Rezoning Transportation Analysis

Petition Number: 2024-037

Date	Description
4-24-24	First Review (JT)
4-24-24	Second Review (TM)
08-22-24	Third Review (TM)

**SCHEMATIC  
SITE PLAN**

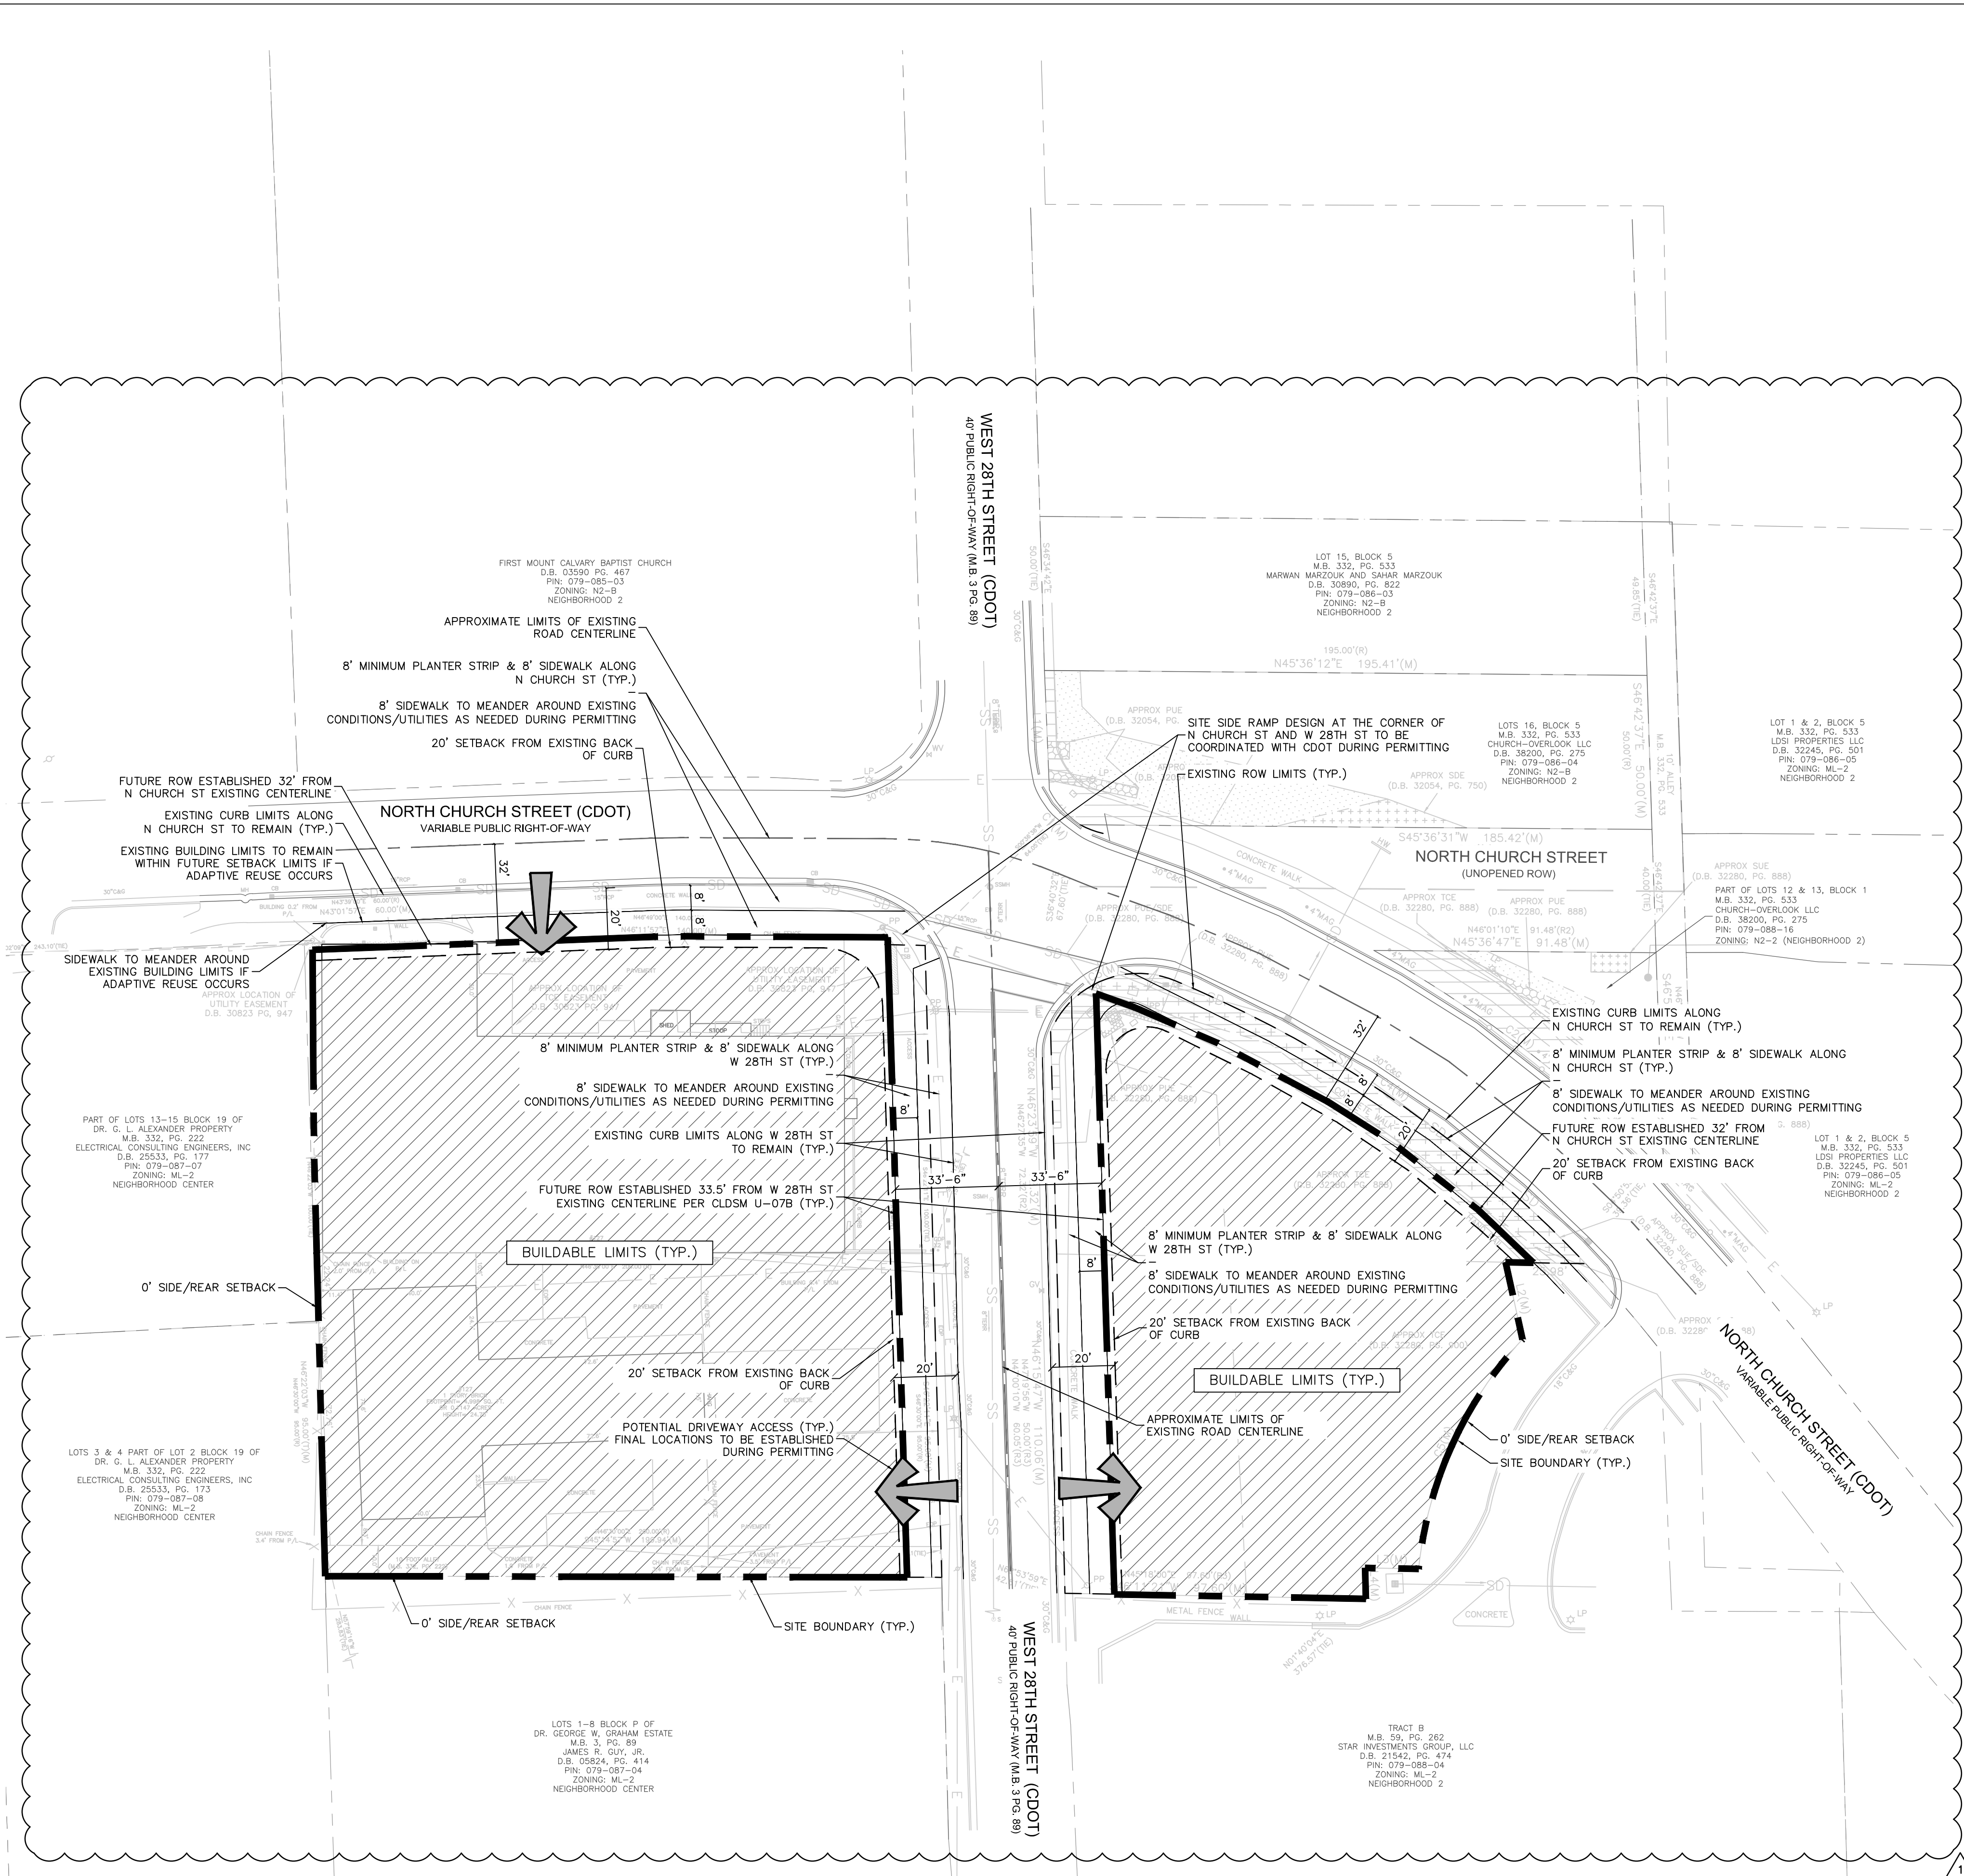
- b. **W 28th Street:** Location of future curb and gutter is to be 17.5 feet from the roadway centerline per CLDSM U-07B.

Label and dimension the curb and gutter from the centerline for each road on the site plan.
